**WELWYN HATFIELD COUNCIL – DEVELOPMENT CONTROL**  
**DELEGATED REPORT**

<b>APPLICATION No:</b>	<b>S6/2010/2260/FP</b>
------------------------	------------------------

The proposed development is an amended scheme to the approval under reference S6/2009/1922/FP. The proposal has been enlarged in depth and height and the proposed roof would have a half hipped design.

The proposal consists of the erection of an outbuilding to the rear of the site. The proposed outbuilding would approximately measure 11.2m in width by 4.6m in depth with a pitched roof to a maximum height of 4.5m. The proposed eaves height would has been dimensioned to be 2.4m at the top of the gutter and a maximum eaves height of approximately 3.2m to the side elevations.

Drawing N°: ELA/6 Rev: 01

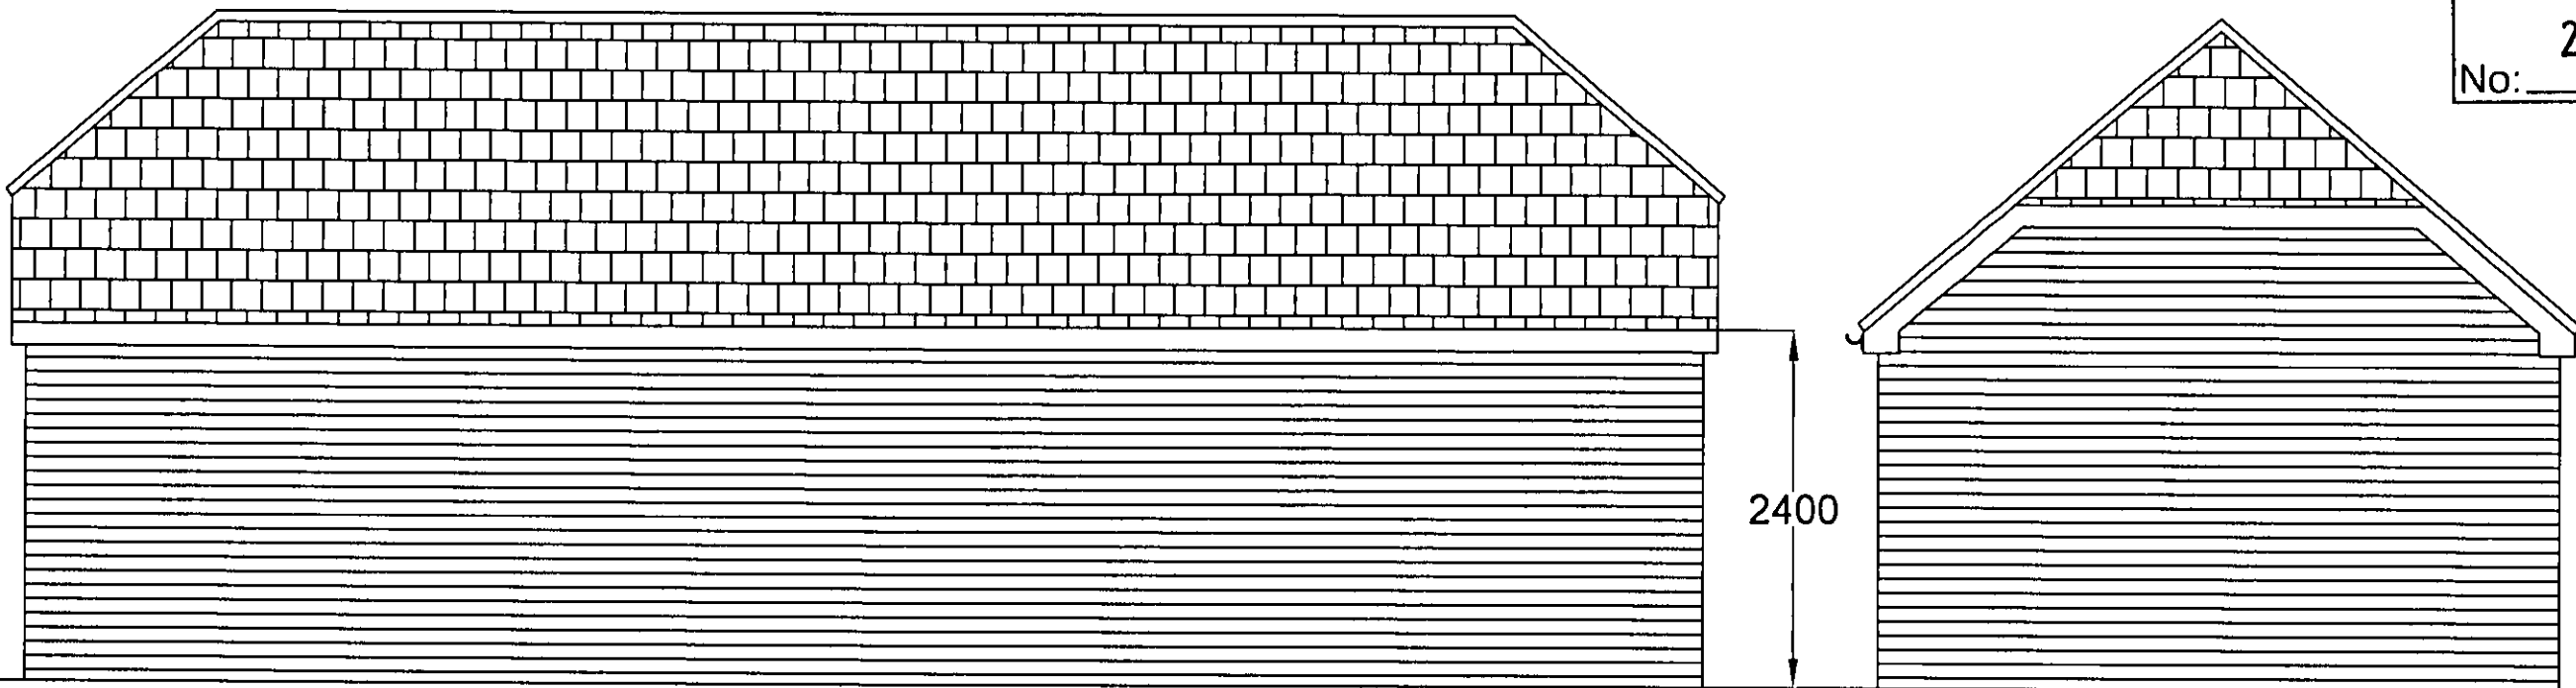
1. The proposed outbuilding would be a larger addition than the development previously approved under application number S6/2009/1922/FP. The proposal would have a bulkier 'Dutch barn' design, with half hipped sides to the roof and a taller ridge height.

The neighbouring plots have outbuildings and sheds, however, the proposal would be approximately 2m higher than the existing adjacent garage and the shed within the application site. Due to the proposed large roof space and bulky design, the outbuilding would appear dominant and too noticeable from the surrounding areas. When compared to the previous approved scheme, the proposal would have a greater height above the adjacent hedge and the scale of this addition would not be

in keeping with the surrounding residential outbuildings. Furthermore, an insufficient amount of space would be retained from the boundaries and the access area to the rear to prevent the proposal from appearing cramped and awkward.

2. The proposed development would be sited closest to number 12 South Drive, which has a frontage near the rear boundary of the application plot. The previously approved scheme had a hipped roof and lower ridge height, which would offset the impact of what would be viewed above the adjacent boundary treatment. However, the proposed outbuilding would have a greater height and a large area would be viewed above the adjacent boundary treatments. The additional bulk of the proposal would be clearly visible and too prominent, when viewed from the neighbouring plot and front facing windows.

The proposed outbuilding would appear too tall, dominant, cramped and prominent within the surrounding streetscene, which would give the proposal an inappropriate appearance for its siting affecting the visual amenities of the streetscene. The outbuilding would also appear too dominant and overly prominent when viewed from the neighbouring property to the north east (12 South Drive). As a result the occupants of this adjacent dwelling would suffer an adverse loss of outlook and residential amenity. The proposed development has therefore failed to meet the requirements of PPS1, East of England Plan 2008 Policy ENV7 and Policies GBSP2, D1 and D2 of the Welwyn Hatfield District Plan 2005
